Ku-ring-gai Council Submission

Major Project MP08_0244 –Environmental Assessment –
Mixed Use Development - 23-37 Lindfield Avenue and 11 Havilah
Avenue, Lindfield

December 2010

1 SEPTEMBER 21 -9AM
1:500

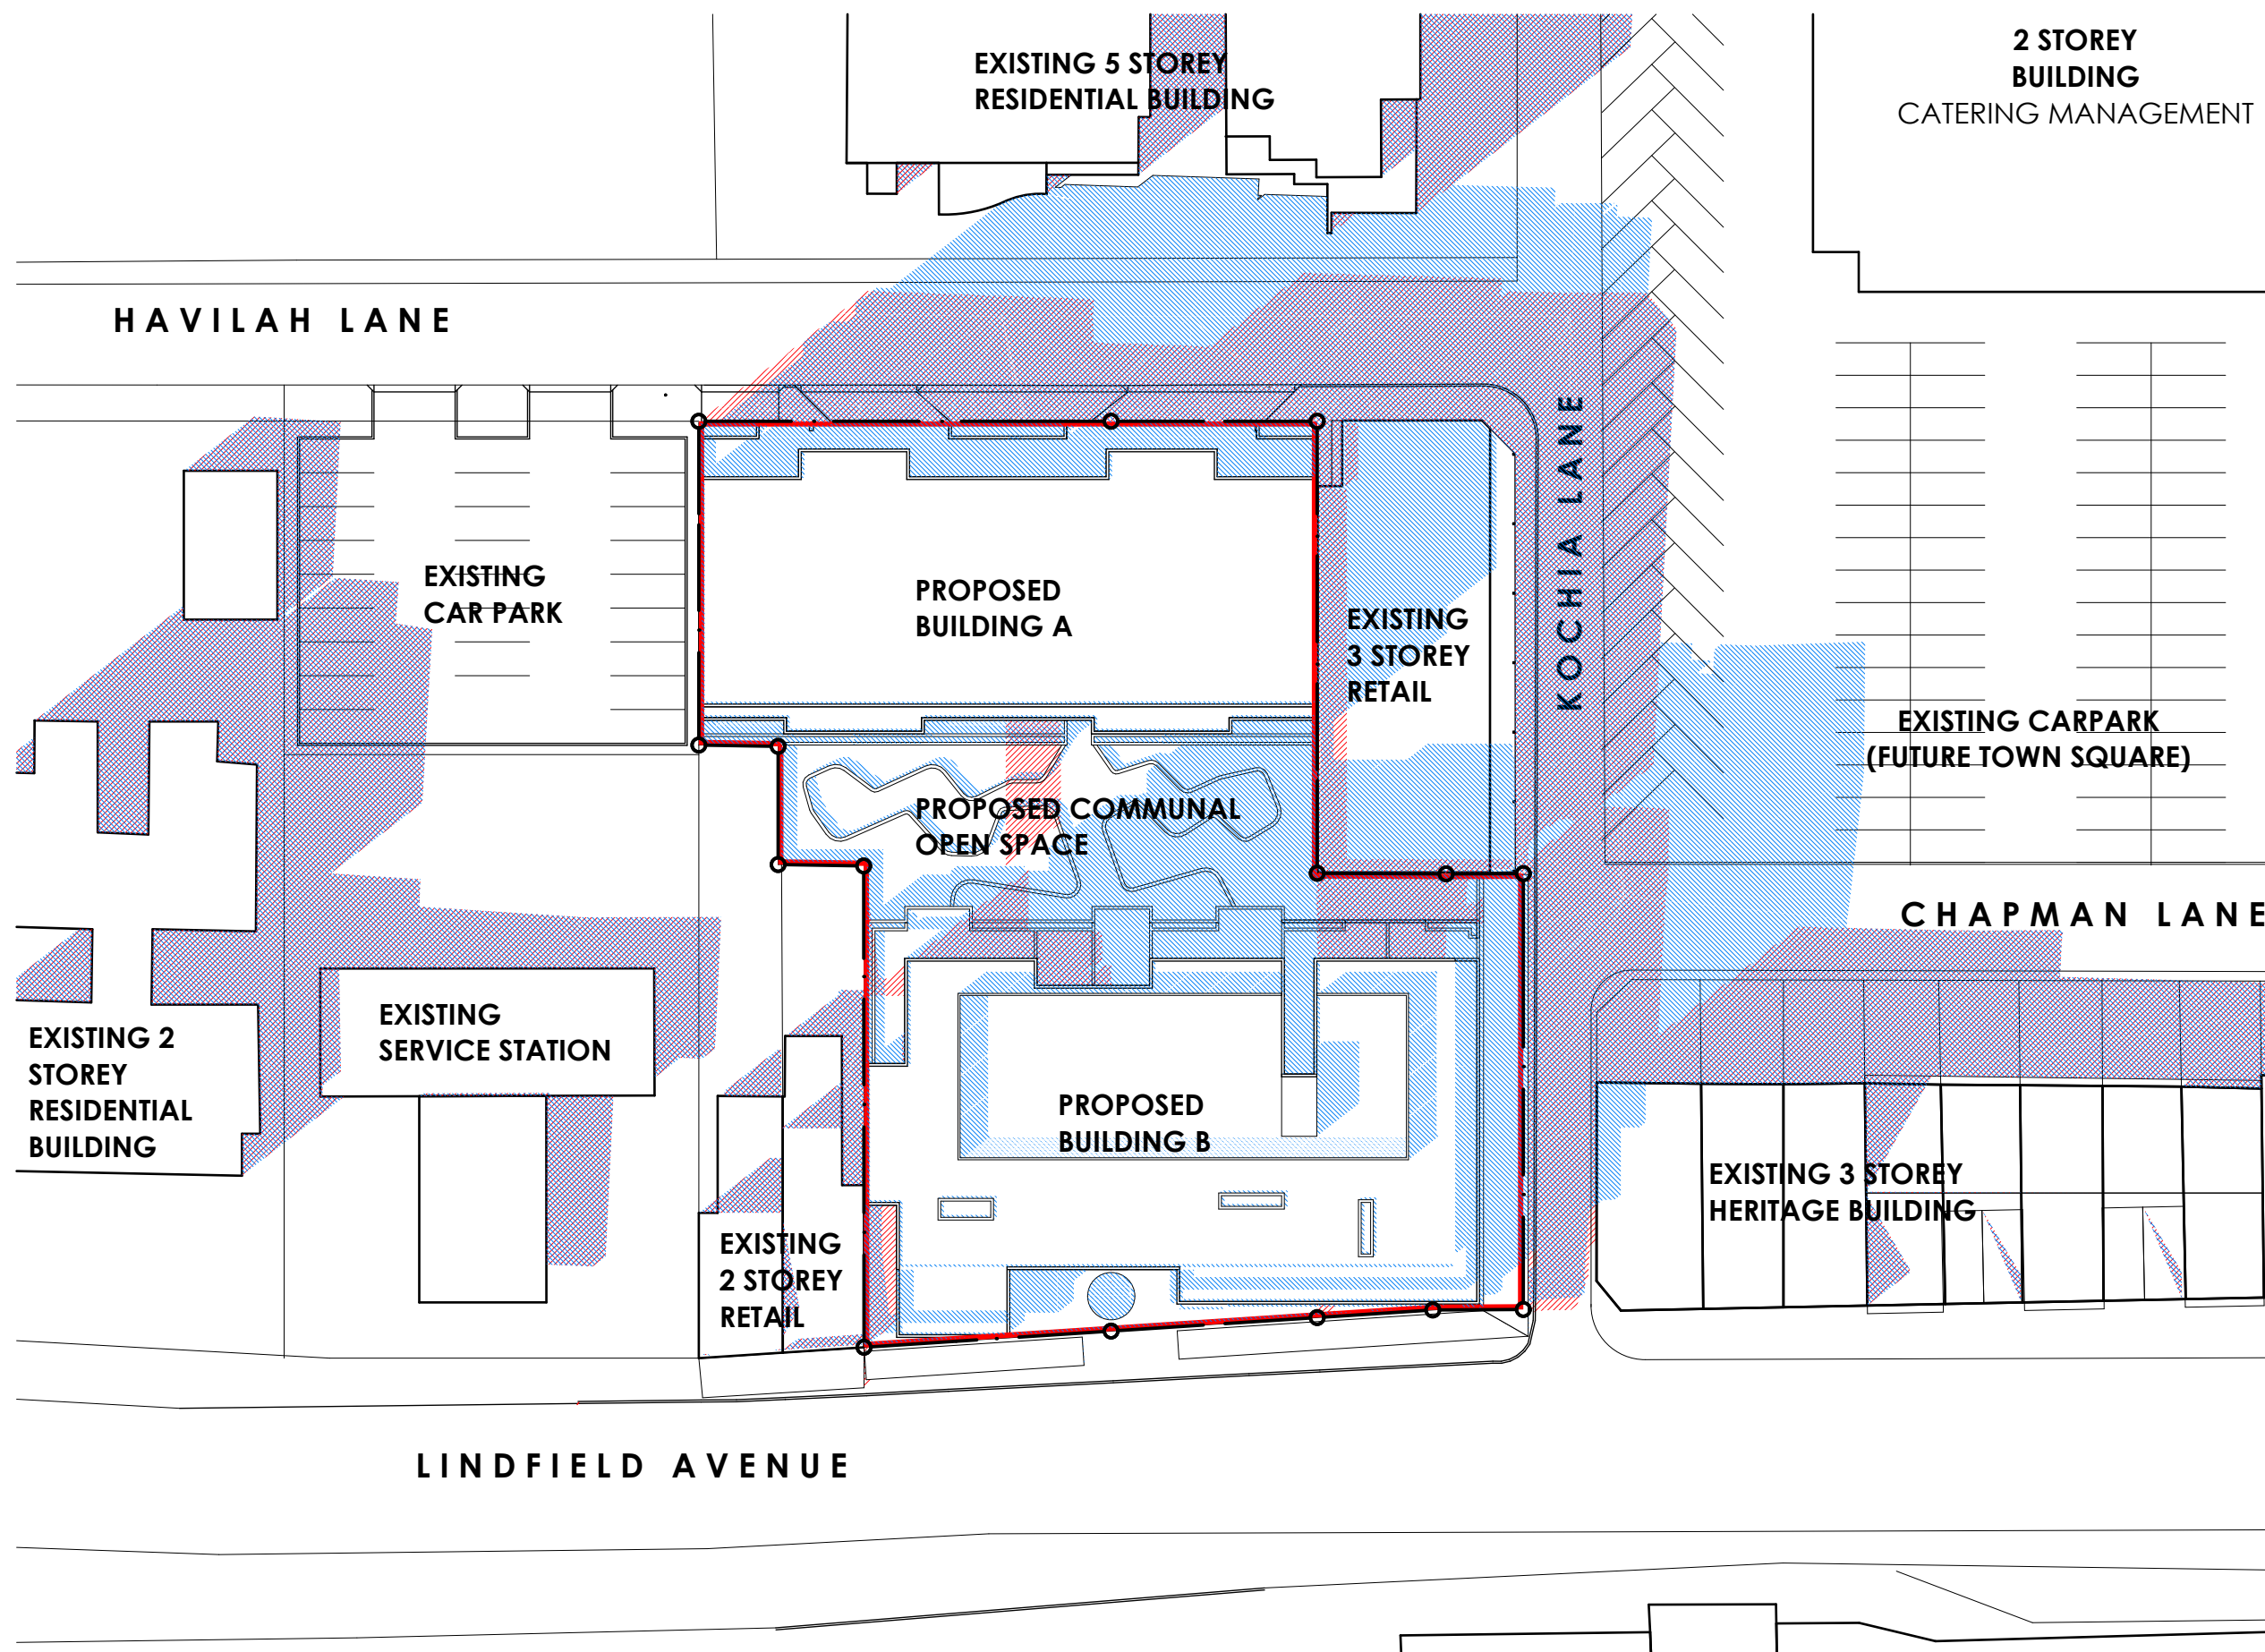
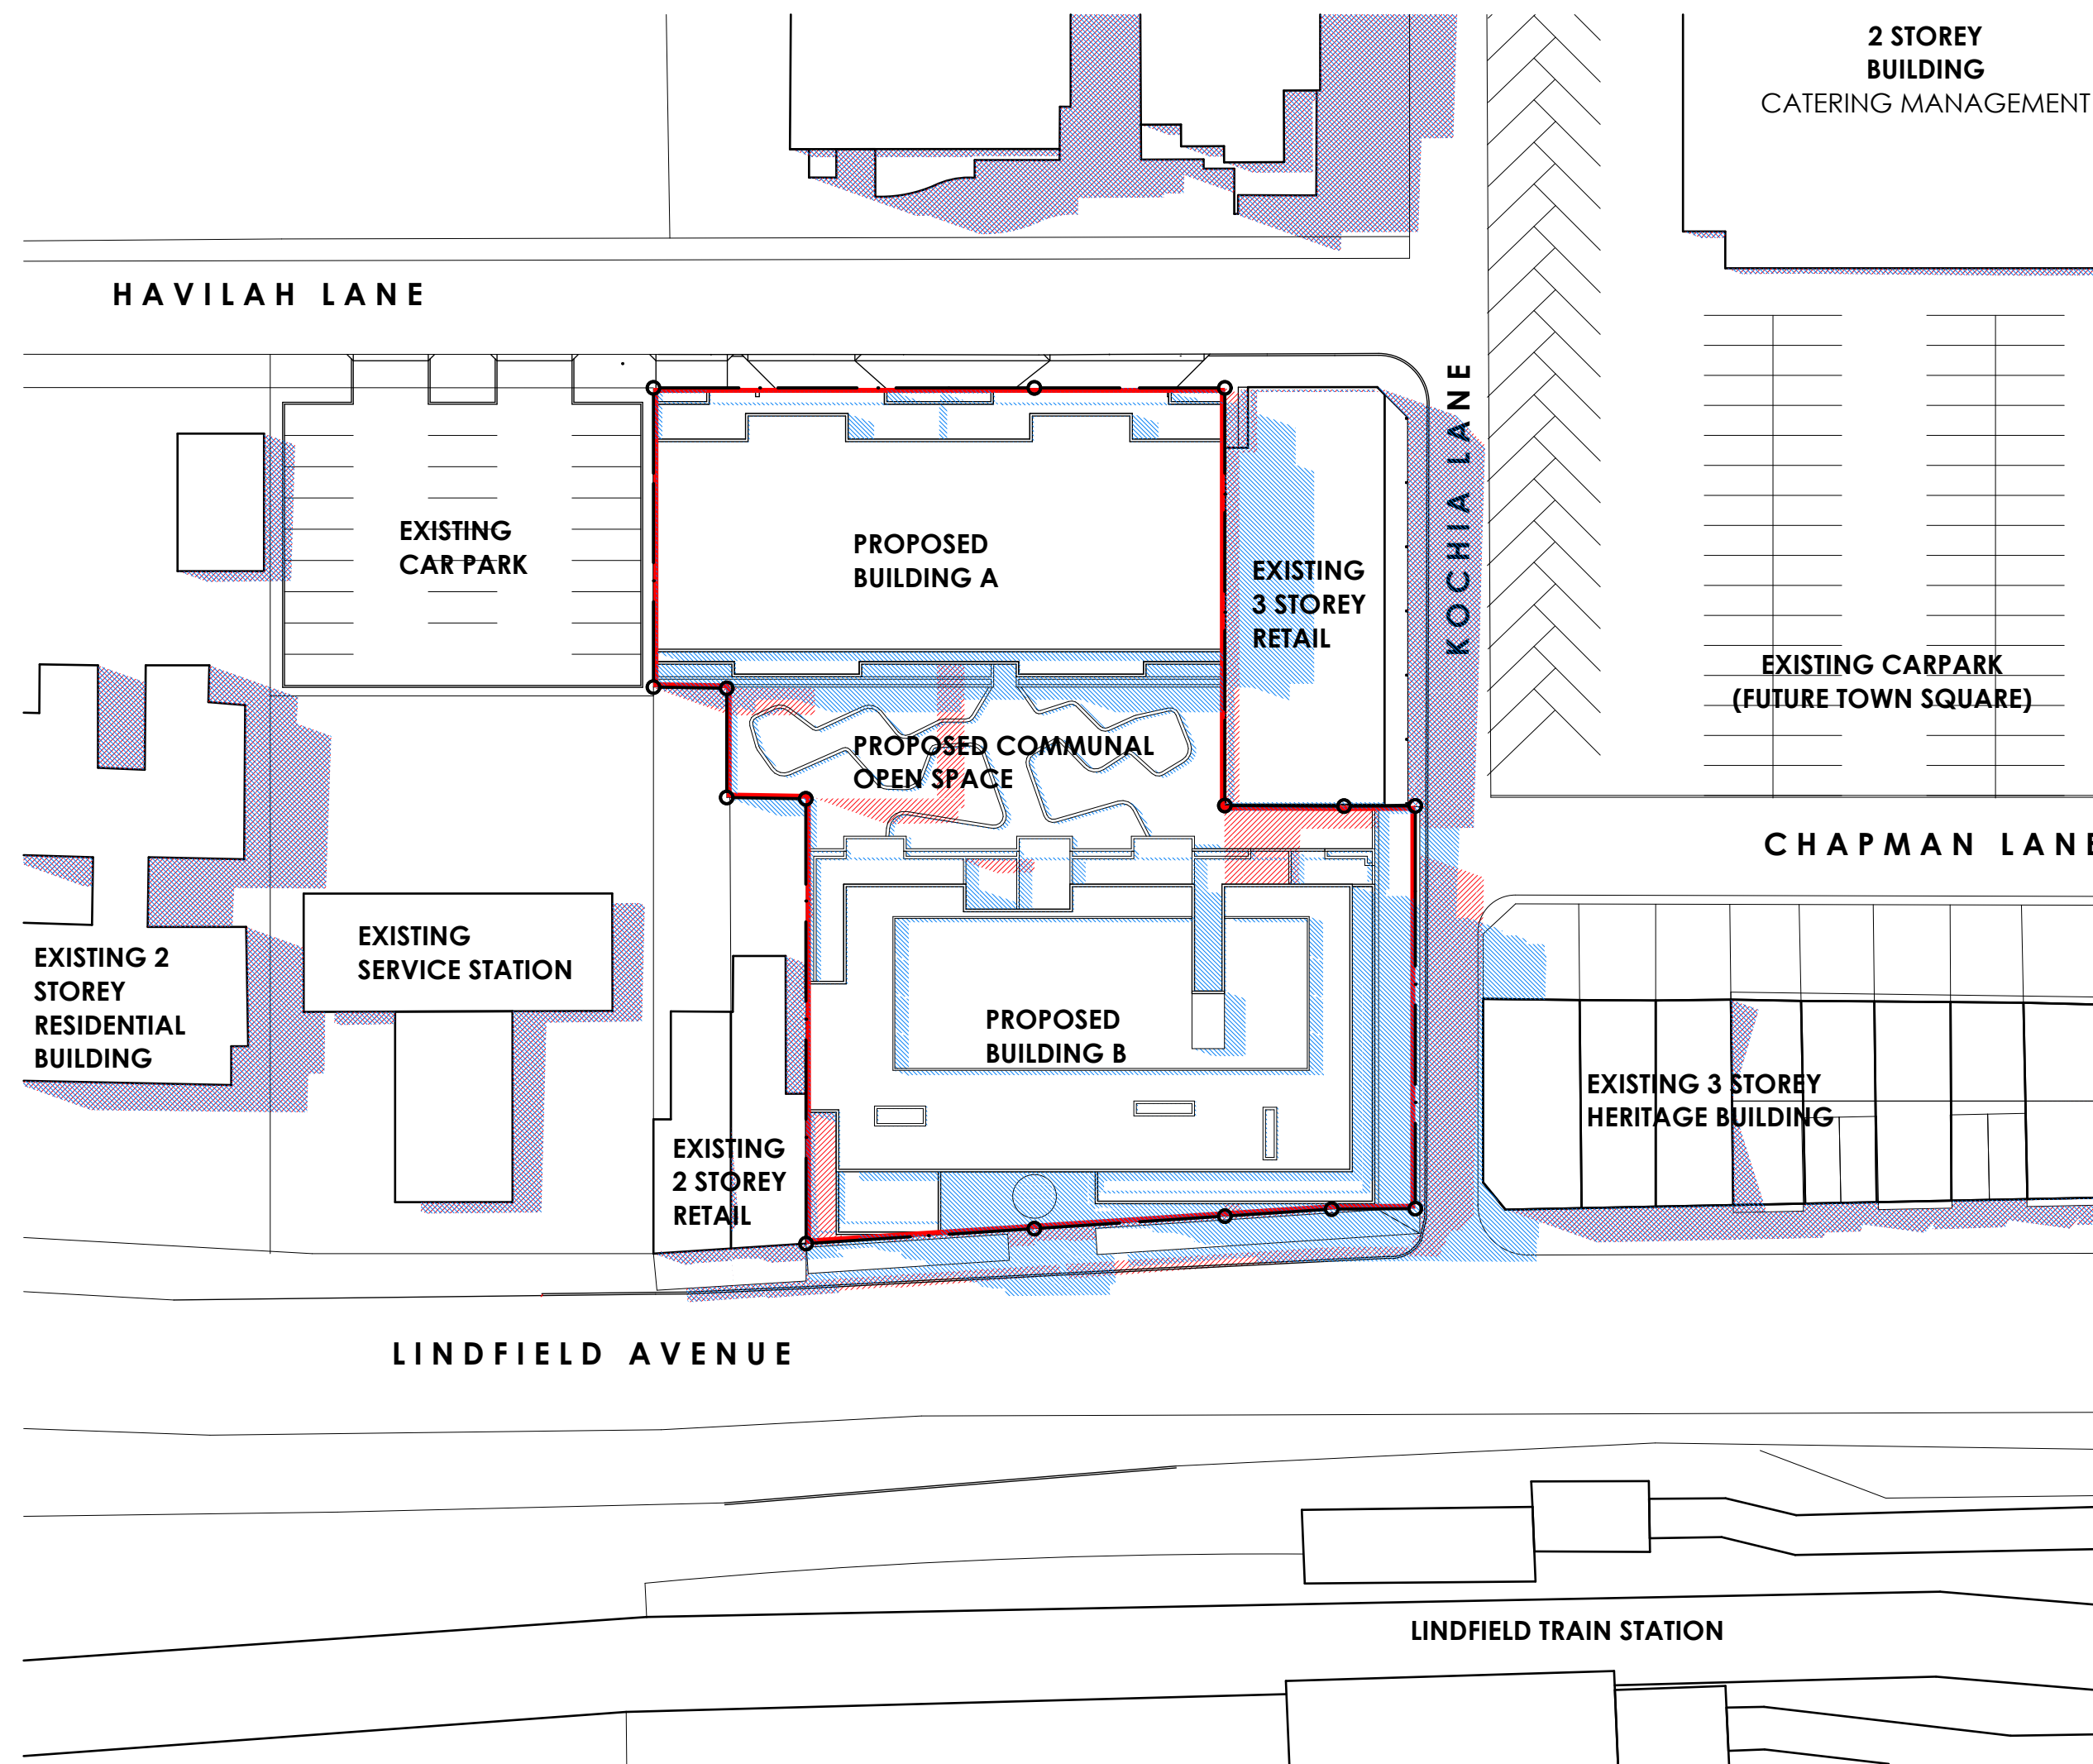
No solar access information was provided to assess compliance with SEPP 65. A report prepared by a suitably qualified person in this field is required. The report should include solar access diagrams/3d modelling addressing solar access requirements in the Residential Flat Design Code. The above report should specify the methodology of modelling, the date/time of the images, orientation of shadows cast and contain a compliance table demonstrating the performance of each individual unit referable to the solar access diagrams/3d modelling.

It is stated that the proposal does not comply with SEPP 65 in respect of solar access due to the fact that the development is located in a town centre. This is not considered adequate justification. A vastly improved outcome can be achieved through redesign as the bulk of the overshadowing is by the development itself (Block A to Block B). The inappropriate use of blade walls also significantly reduces solar access.
